Application for a non-material amendment following a grant of planning permission.

Number	<input type="text"/>
Suffix	<input type="text"/>
Property name	Brae Mar
Address line 1	Ash Road
Address line 2	<input type="text"/>
Address line 3	<input type="text"/>
Town/city	Hartley
Postcode	DA3 8ER
Description of site location must be completed if postcode is not known:	
Easting (x)	560524
Northing (y)	167399
Description	<input type="text"/>

<input type="text" value="Erection of a garden wall and gate"/>	
Reference number:	<input type="text" value="21/01052/HOUSE"/>
Date of decision	<input type="text" value="03/06/2021"/>

Previous elevation drawing - K1147_025 Prop Driveway Gate and Wall-A3 (RevA), submitted and approved has been revised now to K1147_025 Prop Driveway Gate and Wall-A3 (RevB).
The difference/change that we notify you of is with the finished shape of the metal railings and head of the driveway entrance gate. The railings were previously proposed to have a dip/curve in the top rail but now they are to be flat/straight.
The entrance gate was also proposed to have a double curvature about it toward the edge of the gate but now propose a single curve to the head of this gate

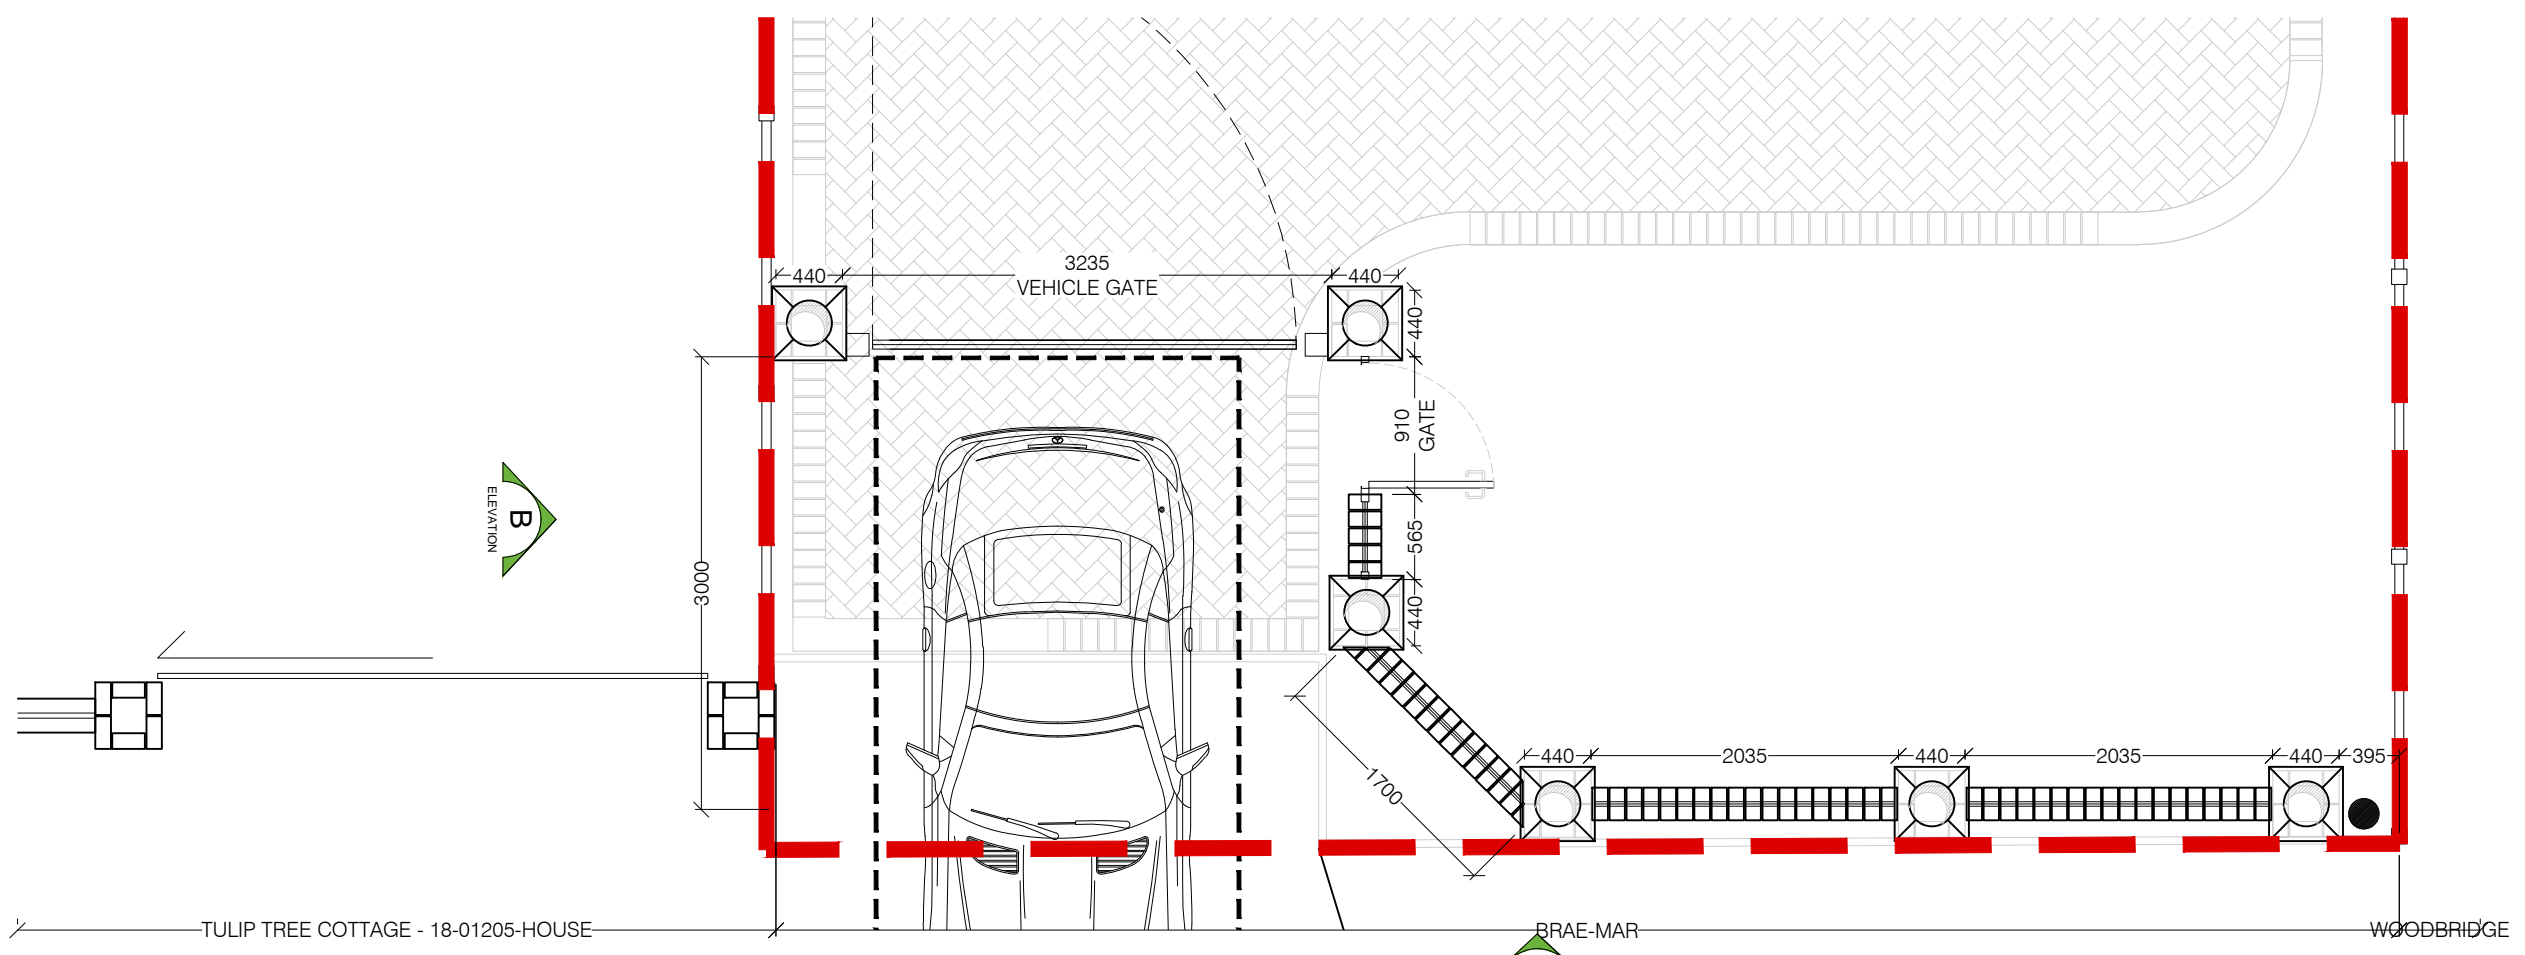
K1147-KLE-DA3-00-DR-A-025 (RevA) - PROP. WALL & ENTRY GATE ELEVATION & PLAN

K1147-KLE-DA3-00-DR-A-025 (RevB) - PROP. WALL & ENTRY GATE ELEVATION & PLAN

As the railings are now a different shape (albeit an extremely small difference and materiality remains the same) our client just wanted to make sure that their application accurately portrayed what has/will be installed on site.
